ATKINS

Our Ref: PLAN-000867

Proposal: Alterations to car park layout, access and landscaping.
Site: Focus, Unit A New Road, Rustington BN16 3RT.
R/149/12/

CHQ.11.9647 - TS PL03

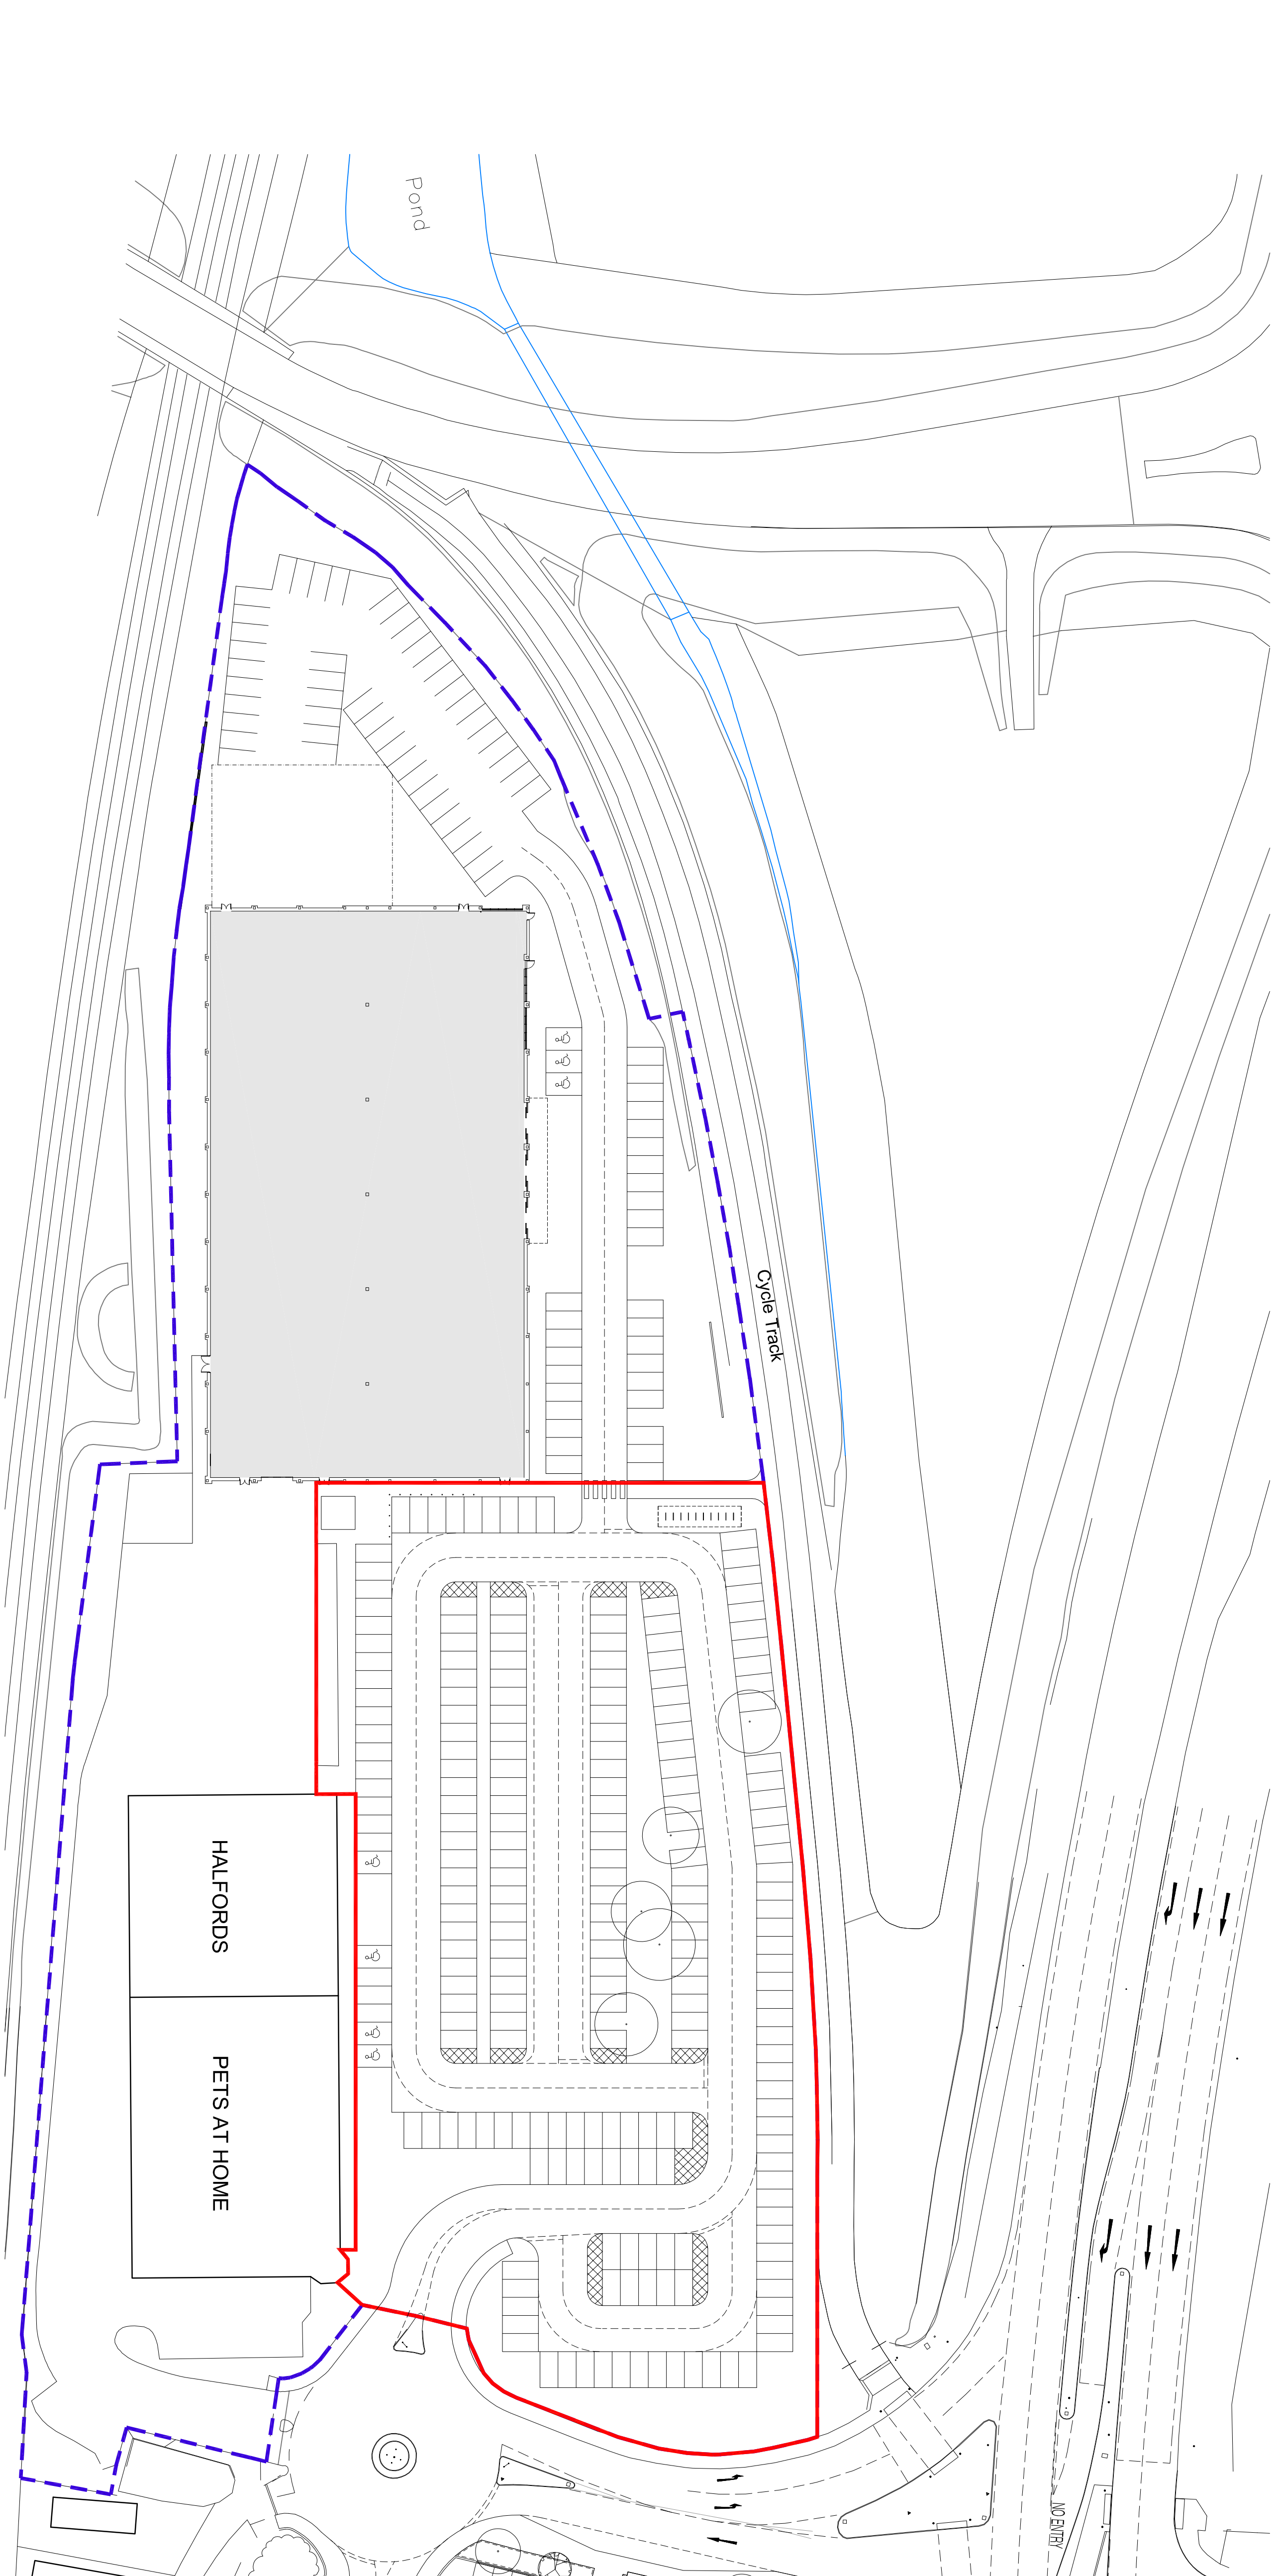
Please find attached a plan of the water main records showing the approximate position of a public water distribution main in the immediate vicinity of the site. The exact position of the public water main must be determined on site by the applicant before the layout of the proposed development is finalised.

All existing infrastructure, including protective coatings and cathodic protection, should be protected during the course of construction works. No excavation, mounding or tree planting should be carried out within 3 metres of the public water main without consent from Southern Water.

The applicant has not stated details of means of disposal of foul drainage from the site.

The application details for this development indicate that the proposed means of surface

water drainage for the site is via a watercourse. The Council's technical staff and the relevant authority for land drainage consent should comment on the adequacy of the proposals to discharge surface water to the local watercourse.

The Council's Building Control officers or technical staff should be asked to comment on the adequacy of soakaways to dispose of surface water from the proposed development.
